CITY OF PORTLAND BUILDING PERMIT

PERMIT ID: 2013-00058

has permission to **Complete rehab. of 3 floors and repair porch.**

Proposed Use: 2 Family	Proposed Project Description: Complete rehab of 3 floors; remove/replace porch & build full dormer on right side
----------------------------------	--

3 WEST ELEVATION
SCALE: 1/4" = 1'-0"

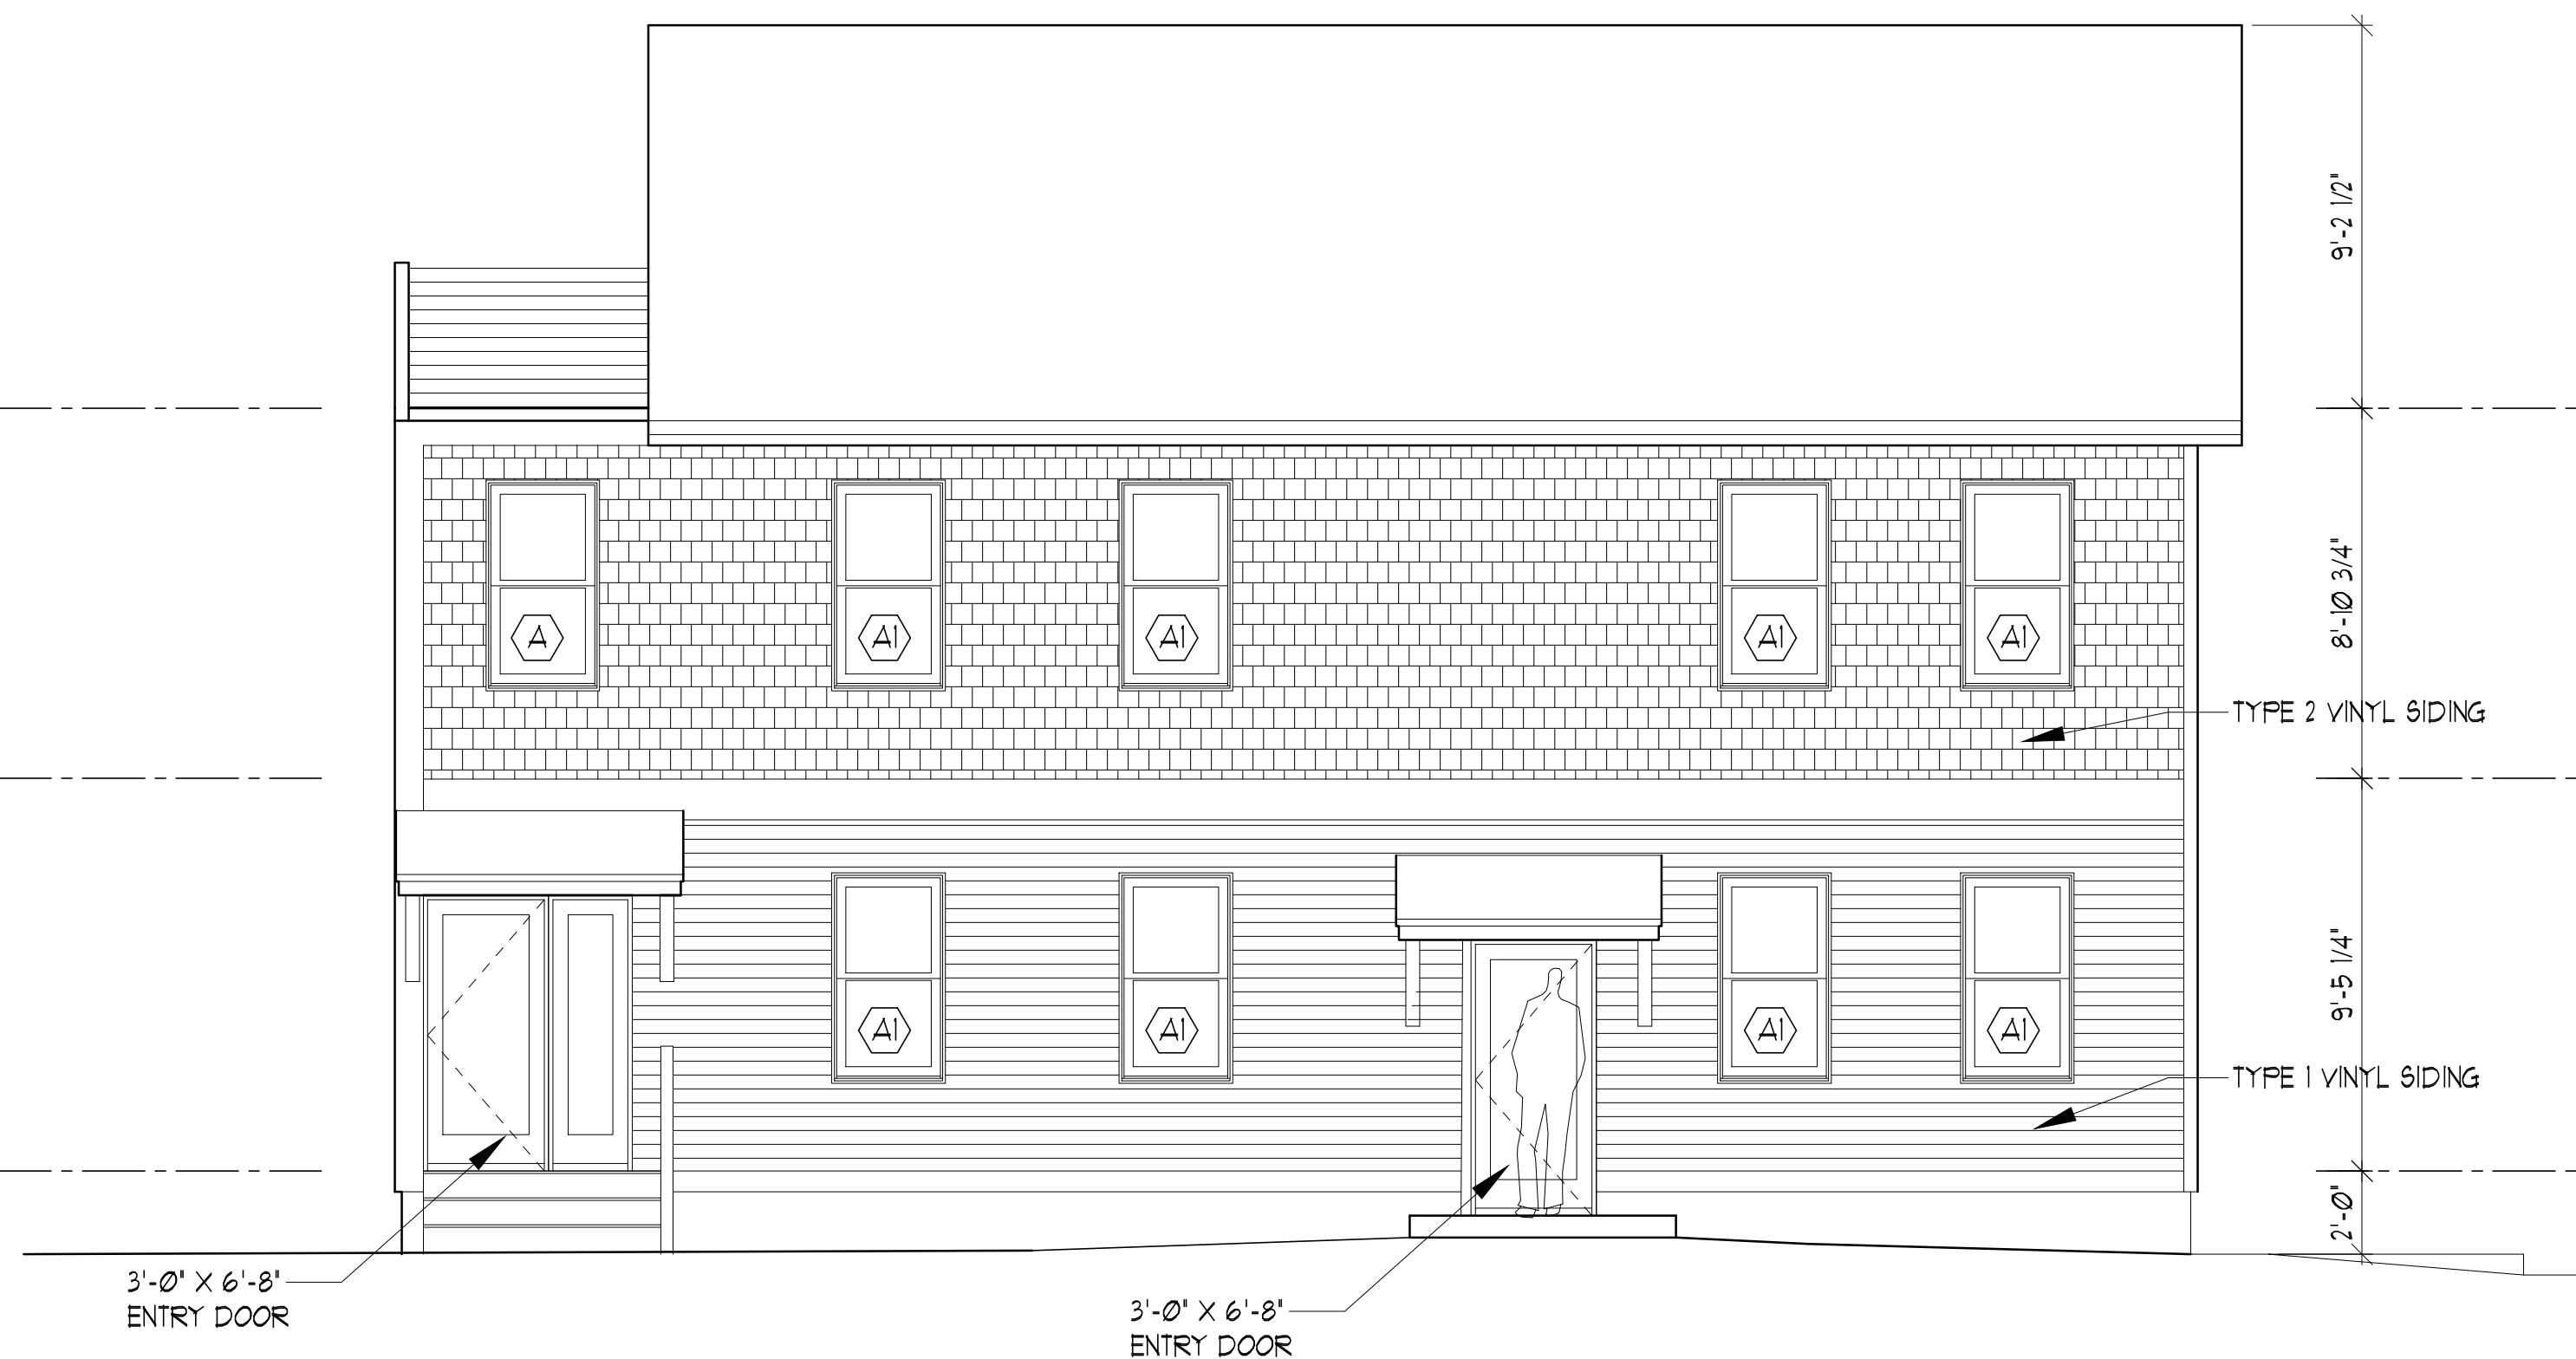
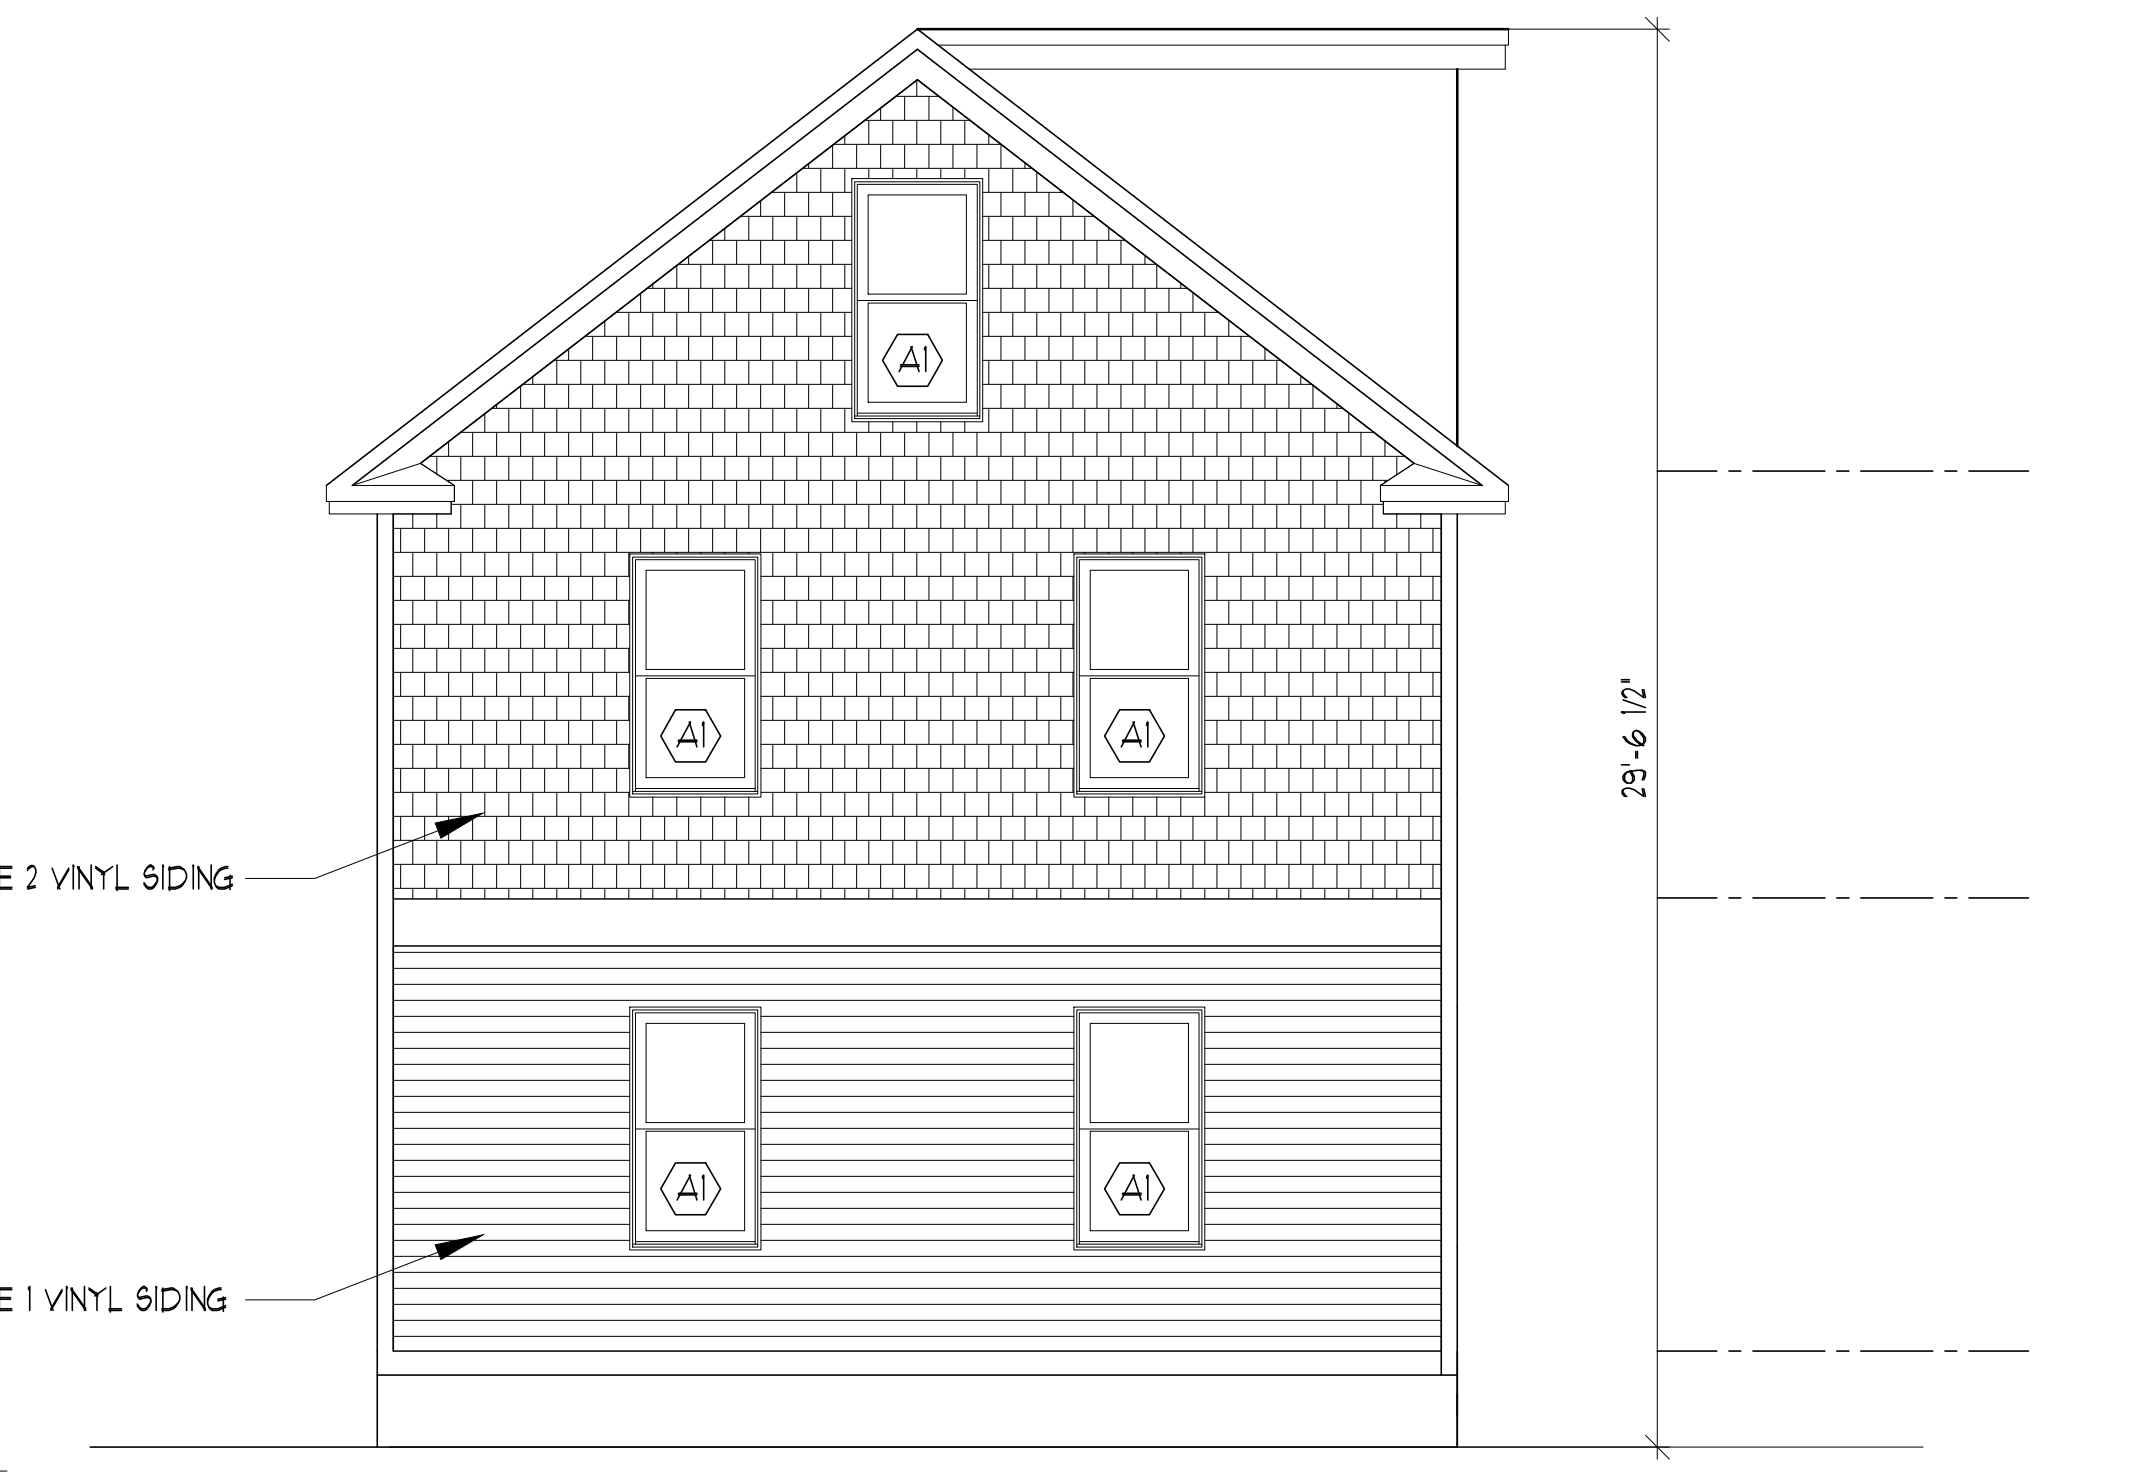
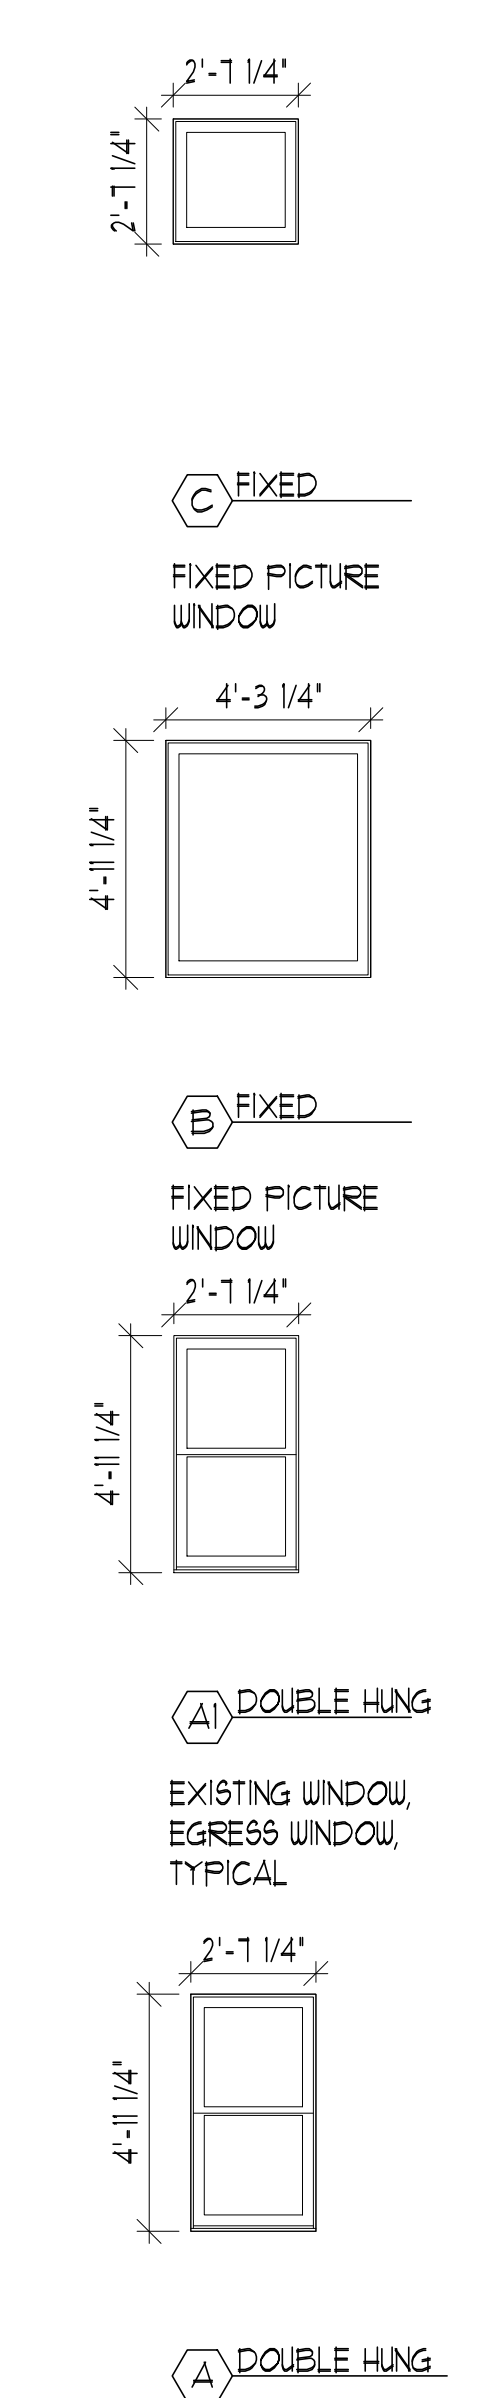
Note: The dormer is being allowed under section 14-436(a). The first floor footprint is 989 sf. The dormer is adding 216 sf. This is a 21.8% increase in floor area. The section allows a 50% increase. **Ok to Issue:**
